Exhibition of Modification Request for Intermodal Logistics Centre at Enfield- Modification 5 (MP 05_0147 MOD 5)

Thank you for providing Bankstown City Council the opportunity to comment on the proposed modification request for Intermodal Logistics Centre at Enfield.

FIGURE 1.3
ILC AT ENFIELD
FILL REUSE AREA LONG SECTION

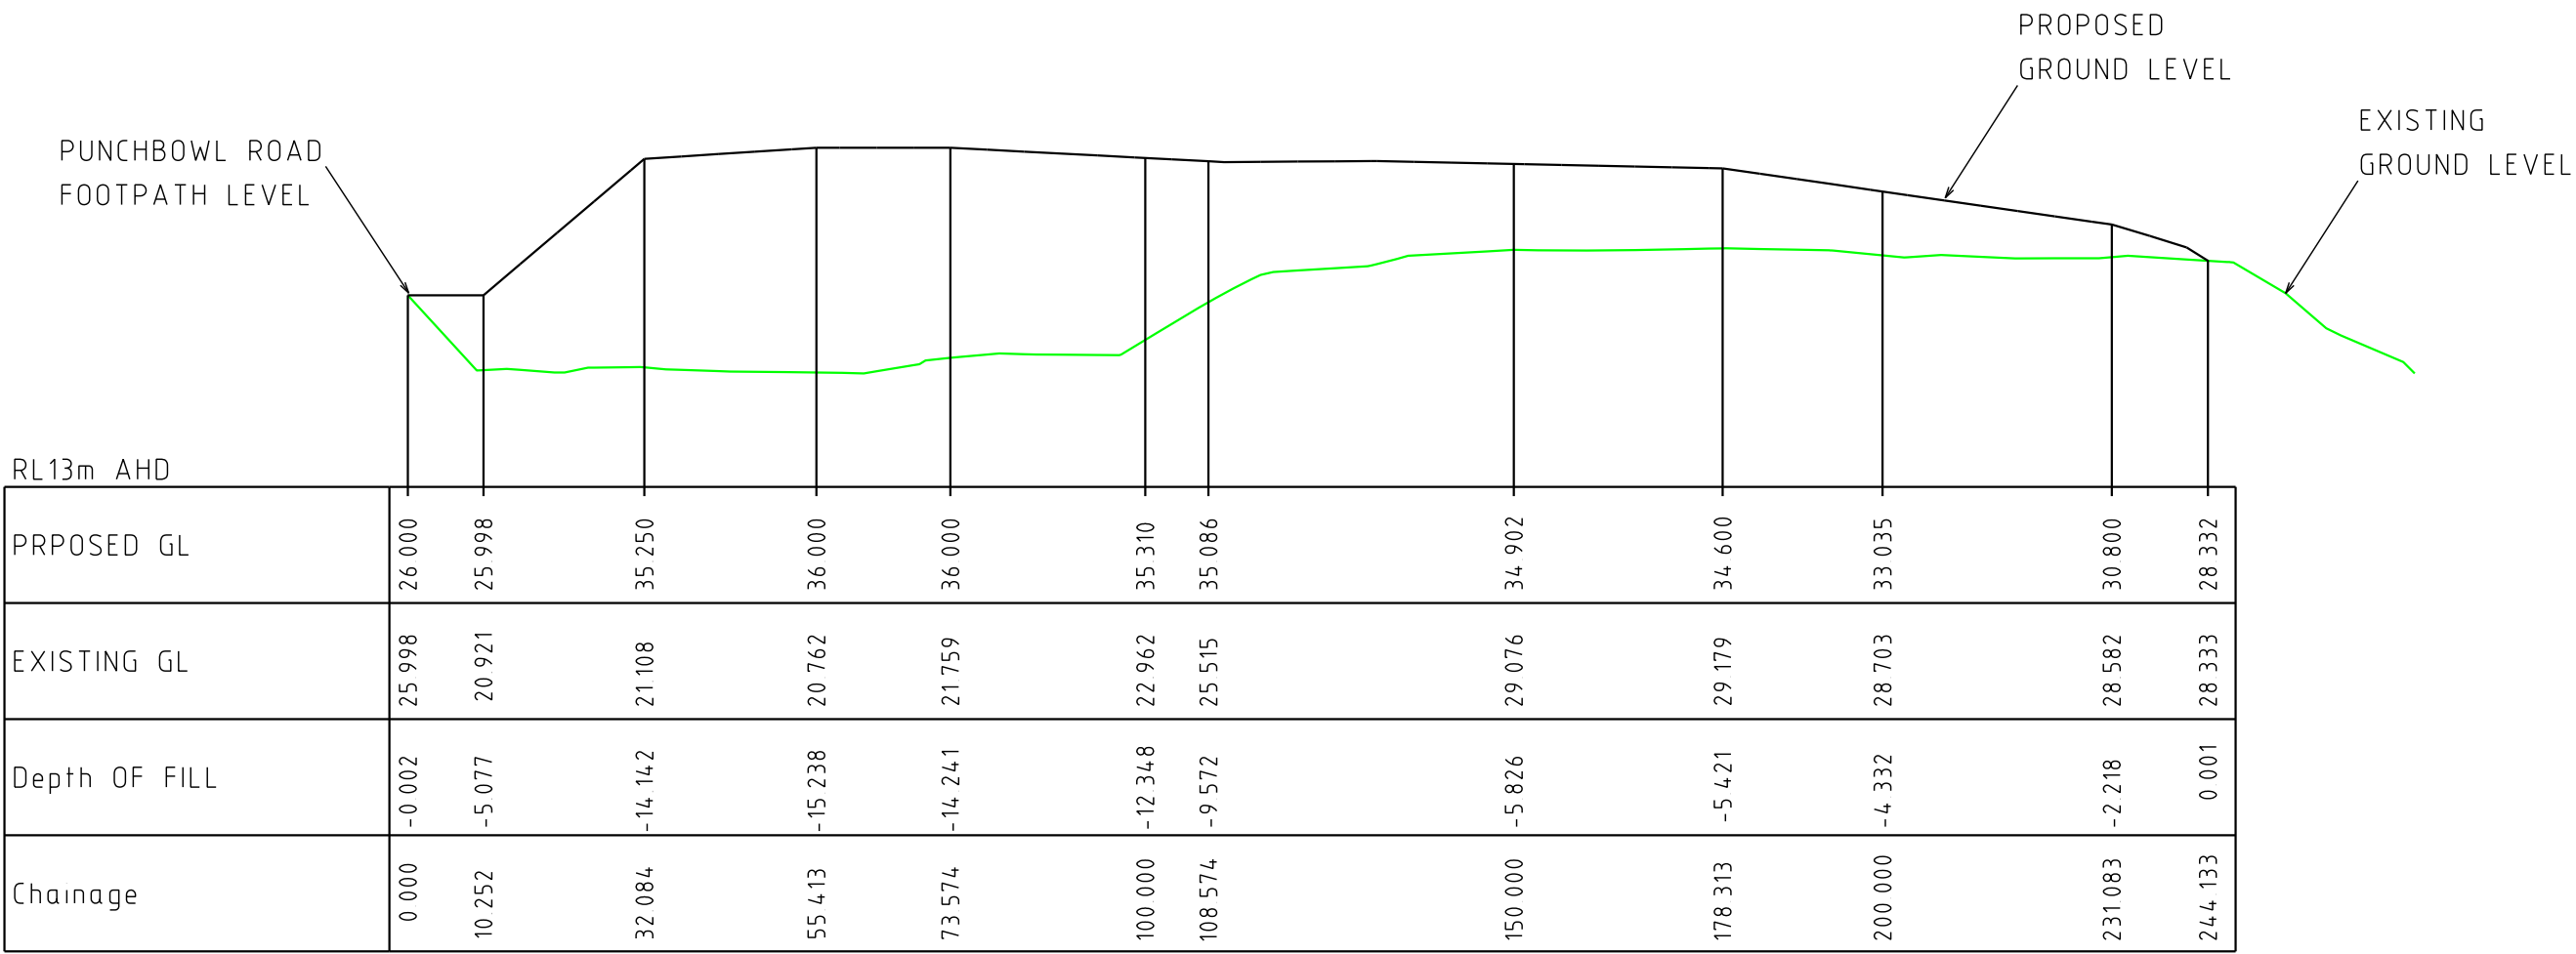
The excess spoil is proposed to be relocated at the southern part of the site on and around Mt Enfield, increasing the height of the hill by 6.7 metres at its highest point.

As indicated in the proposal, the level of the footpath on the northern side of Punchbowl Road is approximately 26m AHD, whereas the highest point of Mt Enfield will be raised from 29.3 m AHD to 36.0m AHD. This means the reshaped Mt Enfield will be visible from a number of residential areas around the locality with most severe impacts to those on the southern part of Mt Enfield, along Punchbowl Road overpass facing north-west and residences fronting Punchbowl Road in the vicinity of the rail corridor with an approximate viewing distance of 20 to 300 metres.

It is recommended that Council and community be consulted for the preparation of a detail Landscape Plan and the Landscape Management Plan.
